16th April 2021

Y/29/21/HH - Erection of garage at The Magnolias,
Church Lane, Yapton

BLOCK PLAN

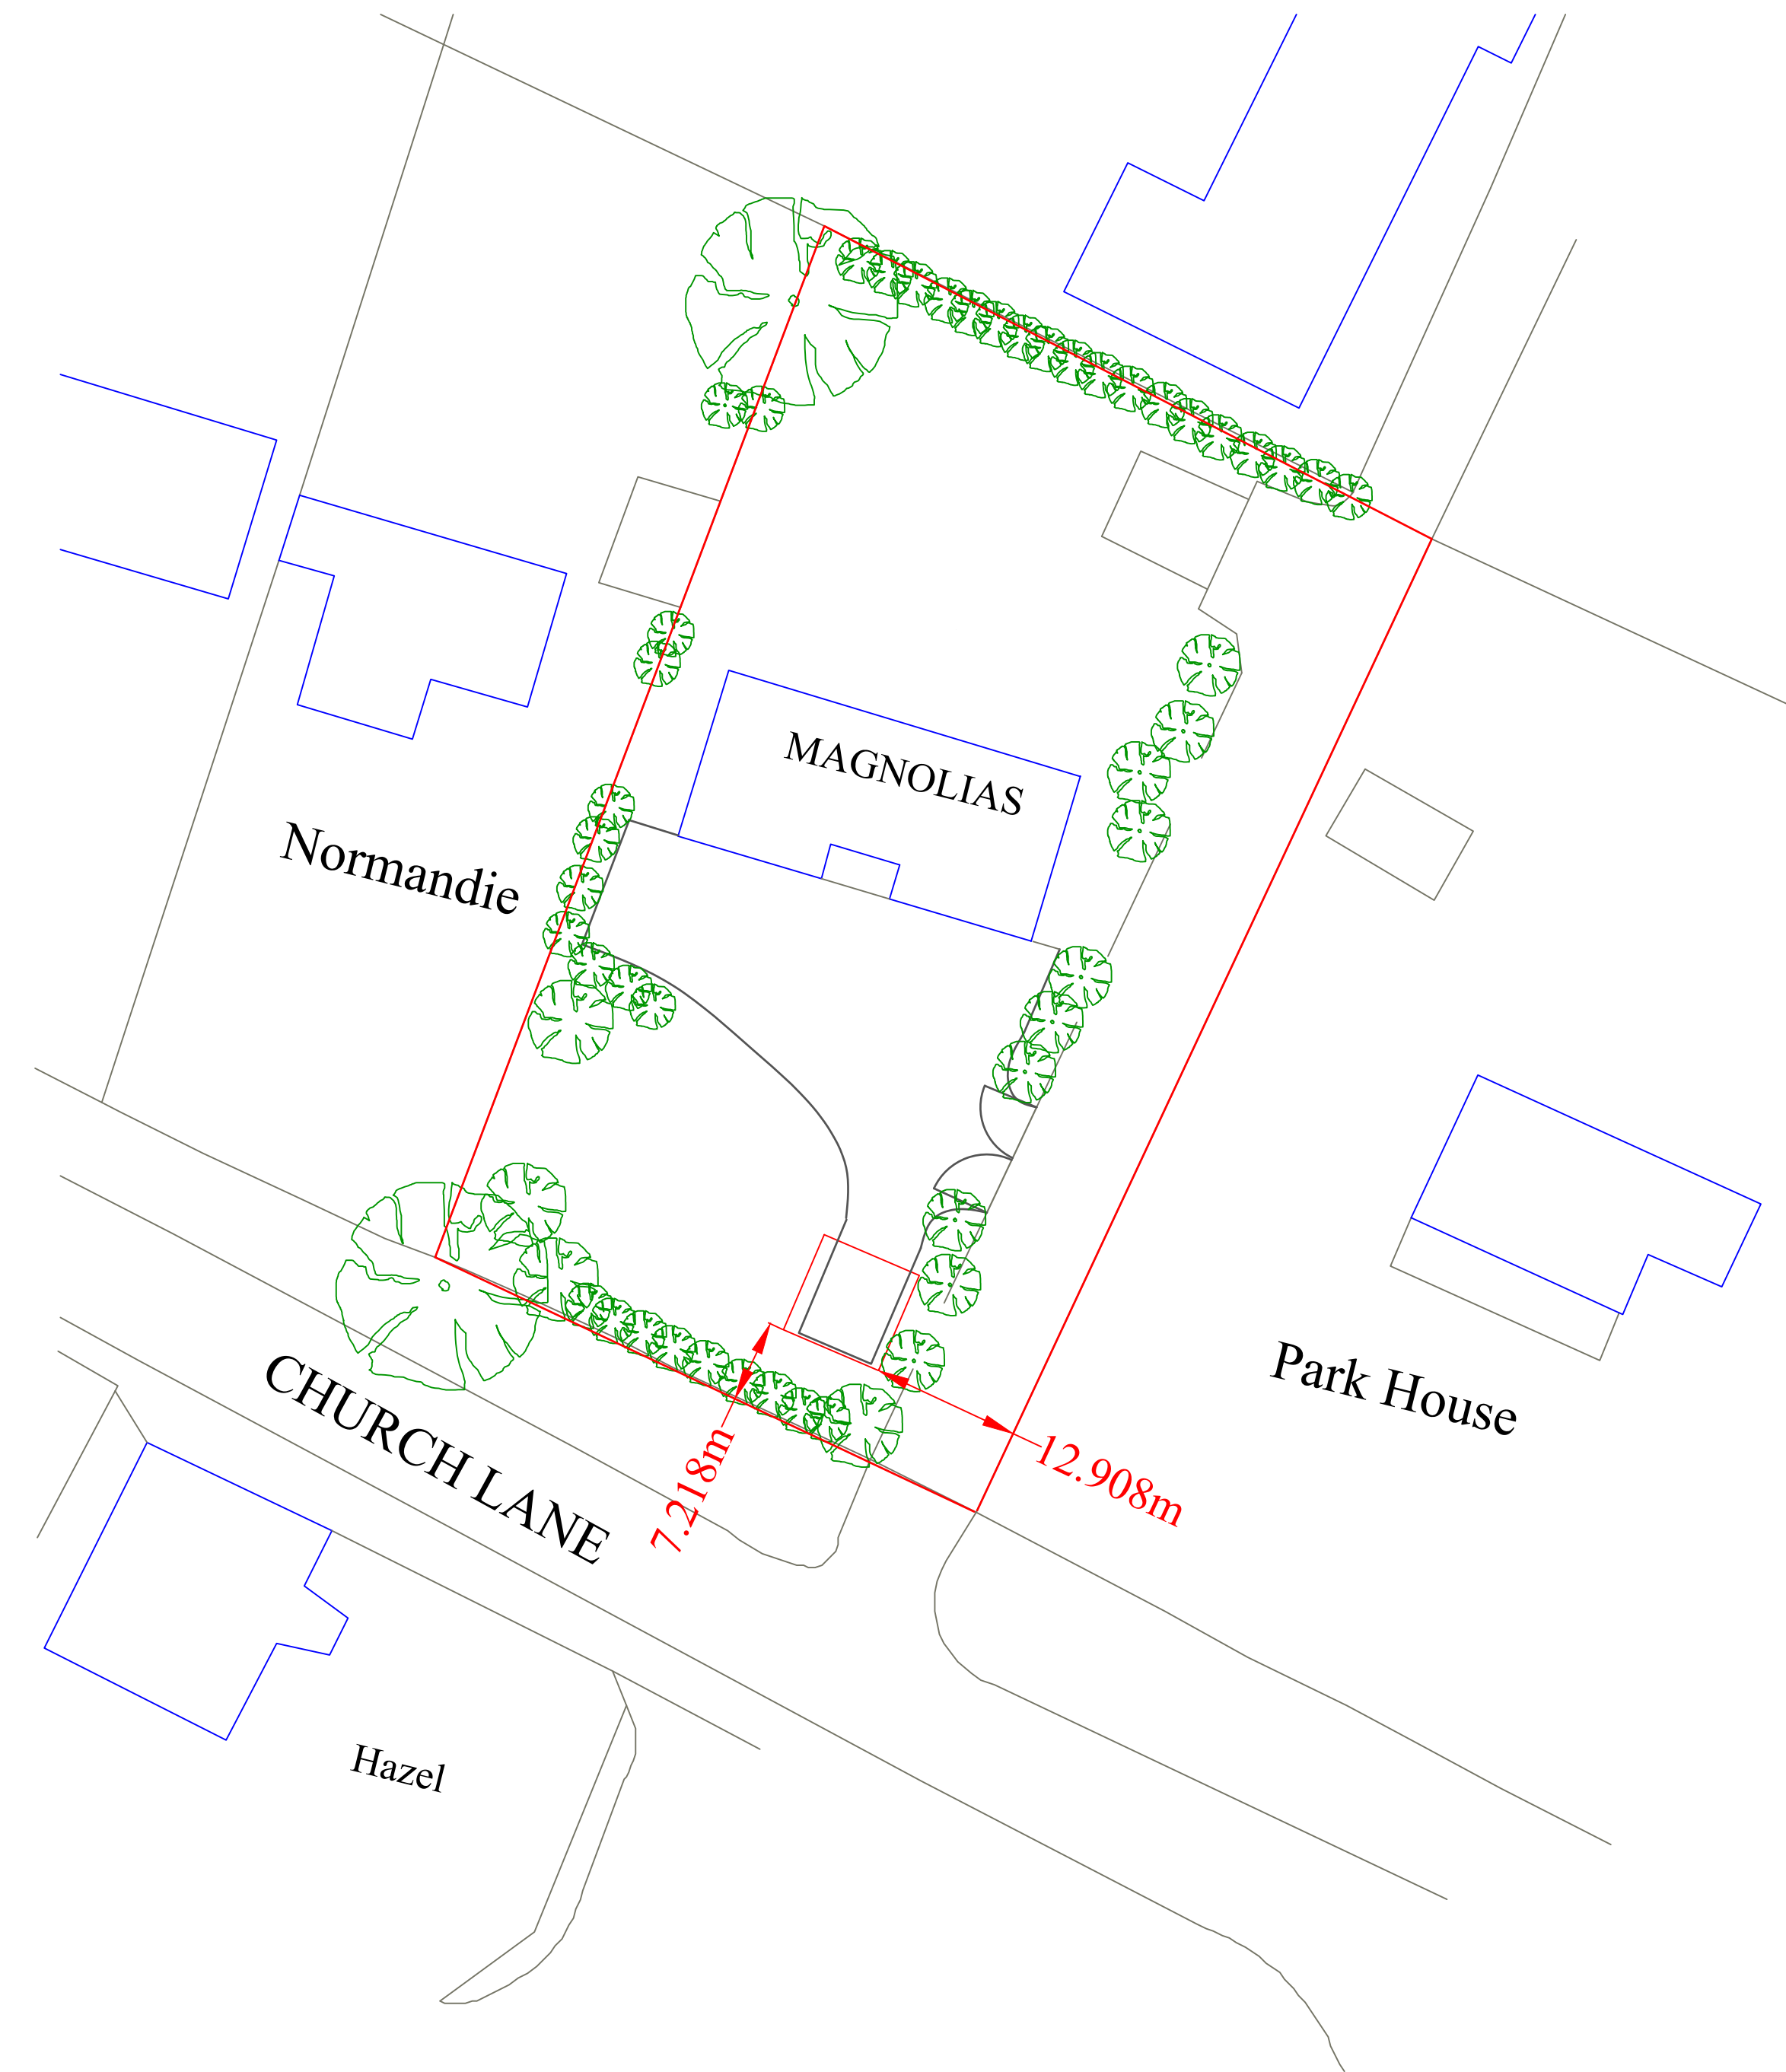
1. The building line for existing adjacent properties, built in the 1850s, is clearly defined in our house deeds - 40 ft back from the roadway. This ensures an open aspect to the street scene.
2. The building will be on raised ground and be a dominant feature when looking along the Lane.
3. The building will be opposite 2 Listed Buildings, Twelfth of Never and Coachmans Cottage, thatched and the oldest ones in the village. The dominant new build will affect their setting and detract from the character of the Lane.
